Address: 8B Oldfield Road Holmfirth HD96RL

| Application number: 2025/92460 | |
| What is the application for?: | Listed Building Consent for installation of new windows and doors, internal alte |

Proposed South West facing Side Elevation
Scale 1:100

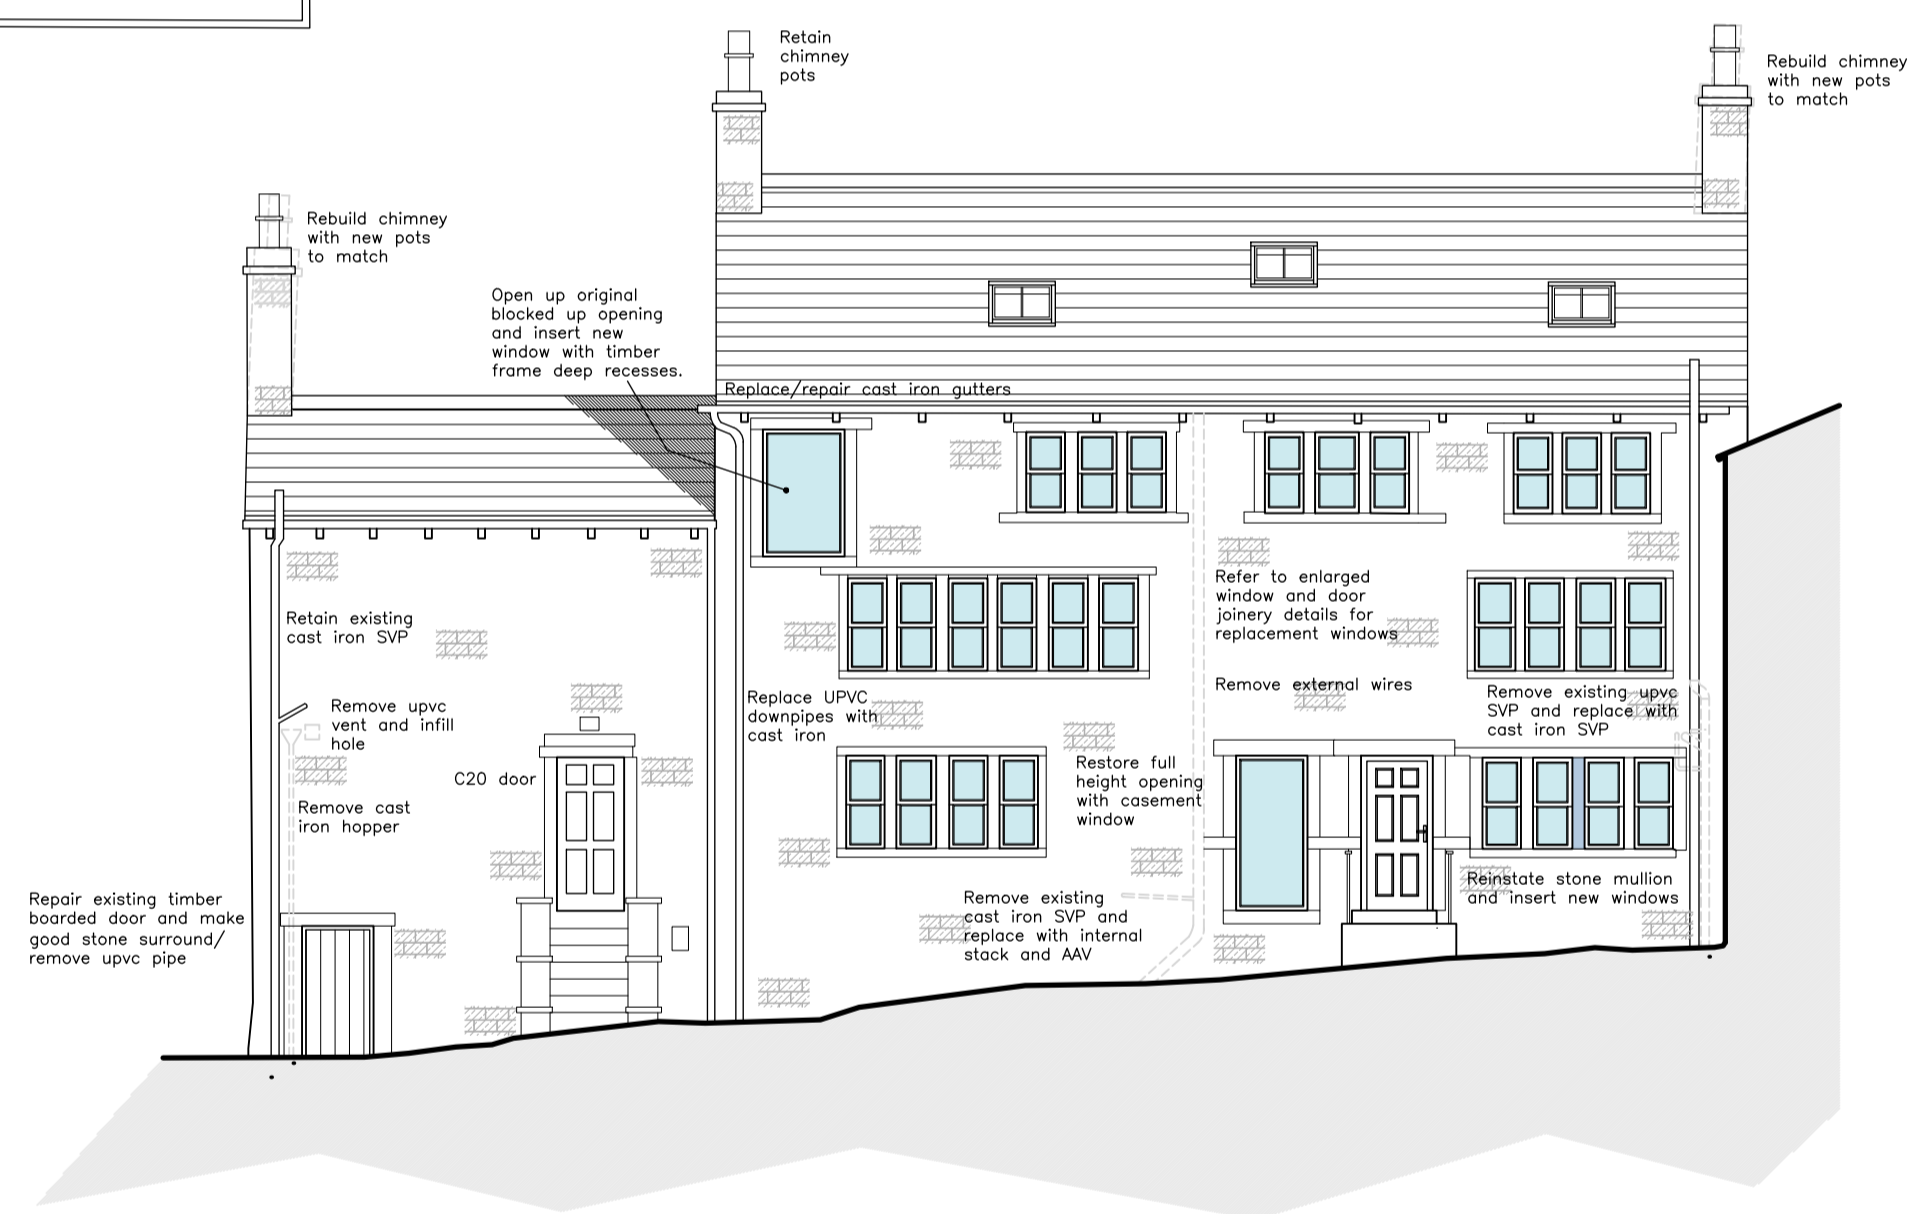
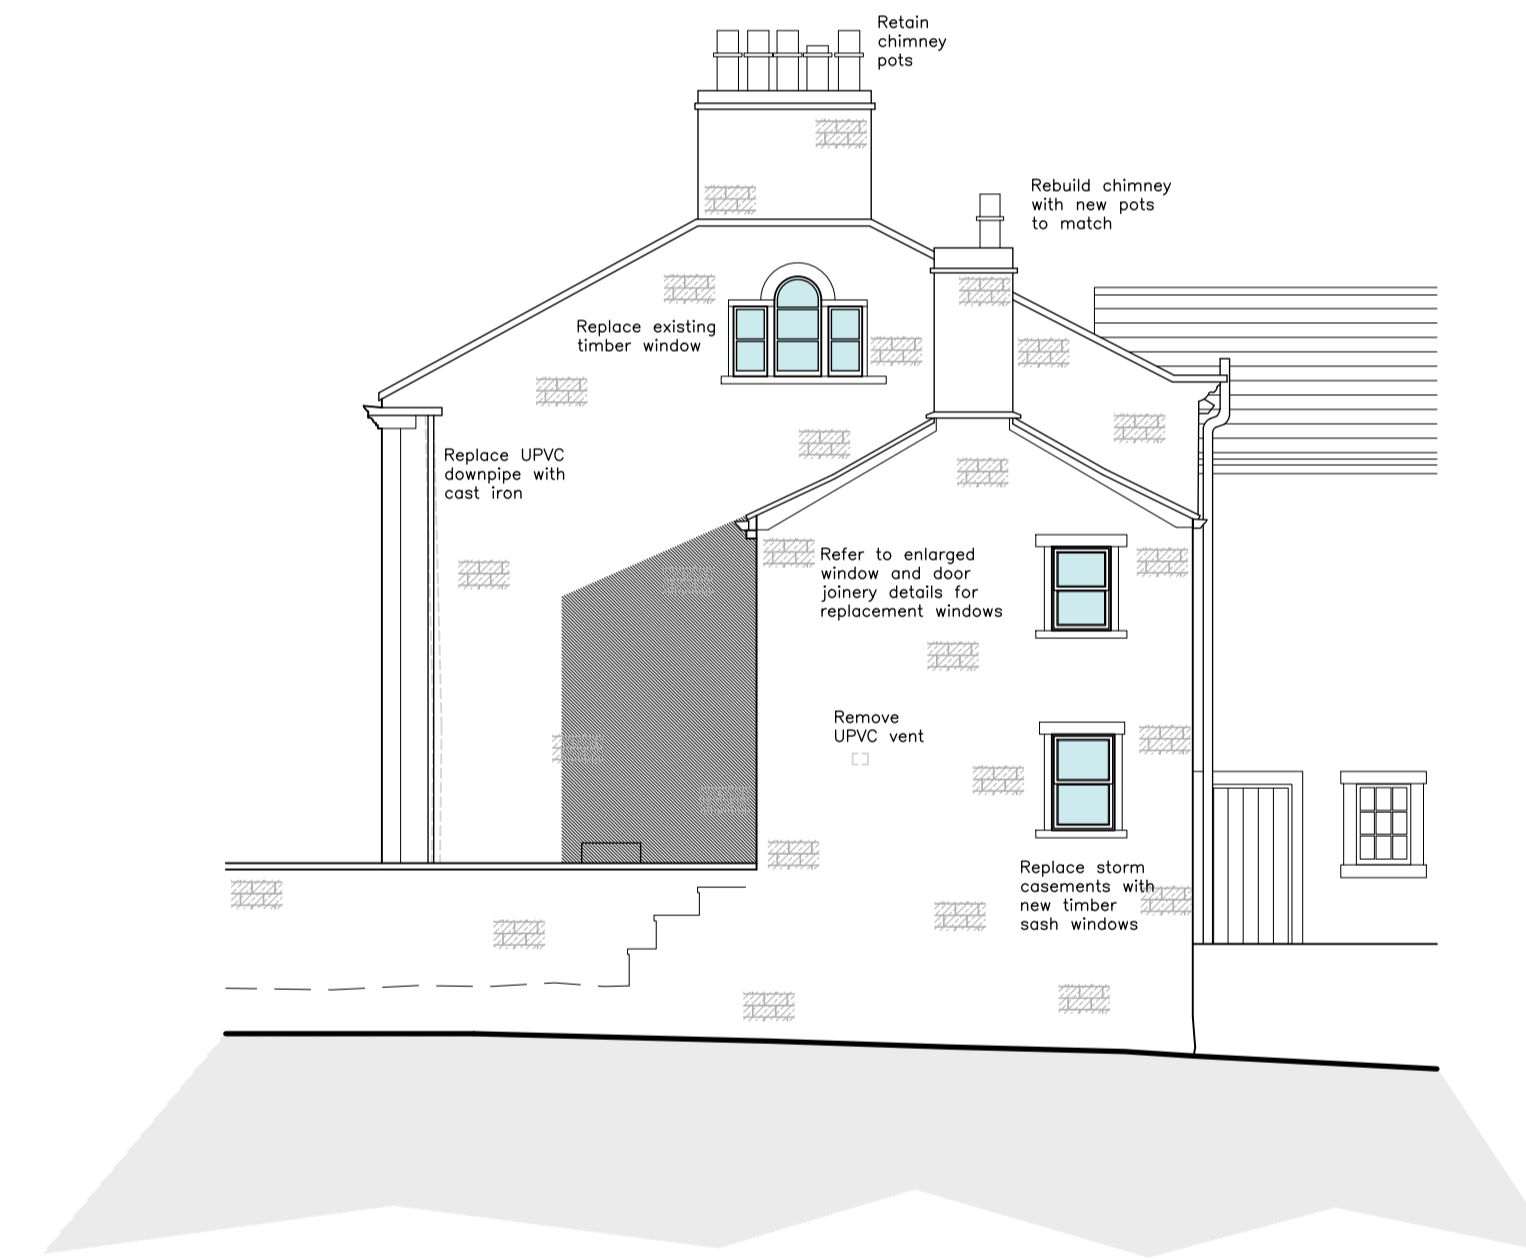
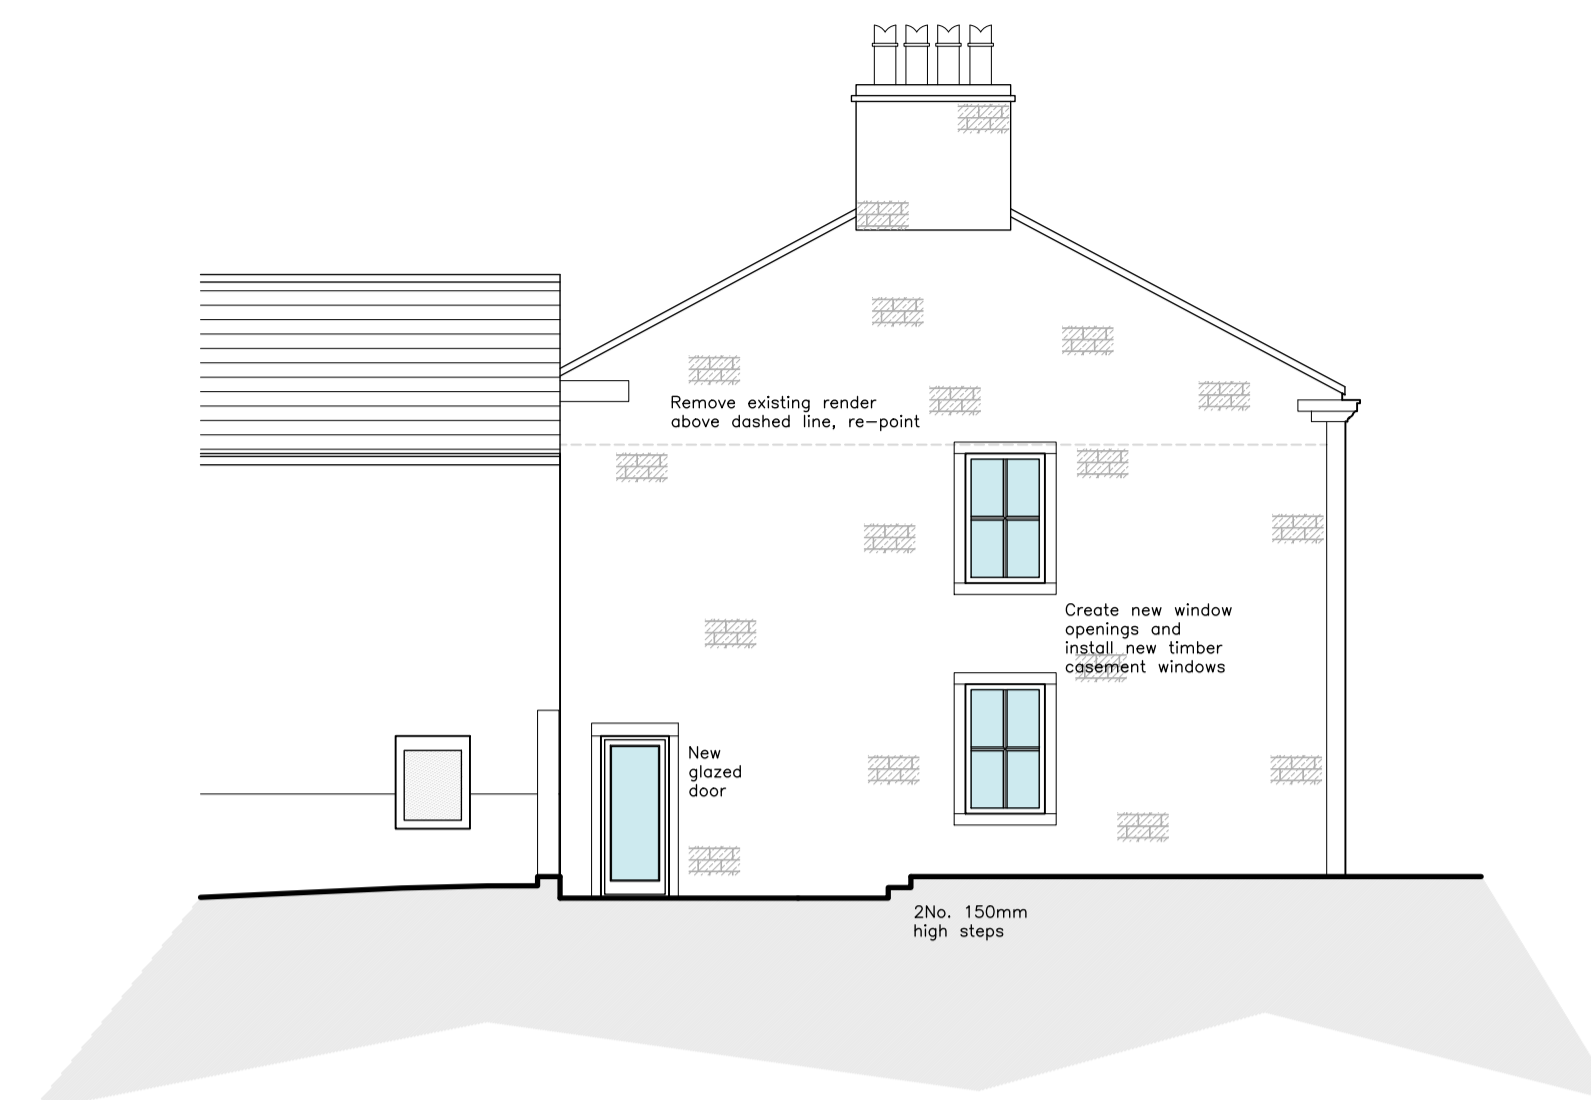
| <p>These plans are based on the ones submitted under applications 2024/91659 & 2024/91658 which were given conditional approval.</p> <p>Condition number 4 in the decision notice for 2024/91658 (id 1057895), relates to the proposed new first floor window in the western gable end (window ref H01 FF-W04).</p> <p>The relevant paragraph is reproduced below. Note that the bedroom references have changed in the latest plans.</p> <p>4. The window within the western side elevation of House 1 hereby approved, to serve bedroom 3 at first floor level, shall be first fitted with obscure glass minimum grade 4. Notwithstanding the provisions of Section 55(2)(a)(ii) of the Town and Country Planning Act 1990 and the Town and Country Planning (General Permitted Development)(England) Order 2015 (or any Order revoking or re-enacting that Order with or without modification), the window shall thereafter be so retained obscurely glazed.</p> <p>Reason: To protect the amenity of the neighbouring property, in accordance with Policy LP24 of the Kirklees Local Plan, Chapter 12 of the National Planning Policy Framework, Policy 2 of the Holme Valley Neighbourhood Development Plan and Principle 6 of the Housebuilders Design Guide SPD.</p> <p>After talking to the new owners, we understand that this first floor window may now not be required. To avoid the time & cost involved with resubmitting amended plans, we'd like to request that 'condition 4' is retained for window ref FF-W04 whilst it remains in any approved plans please.</p> <p>Thanks</p> | |
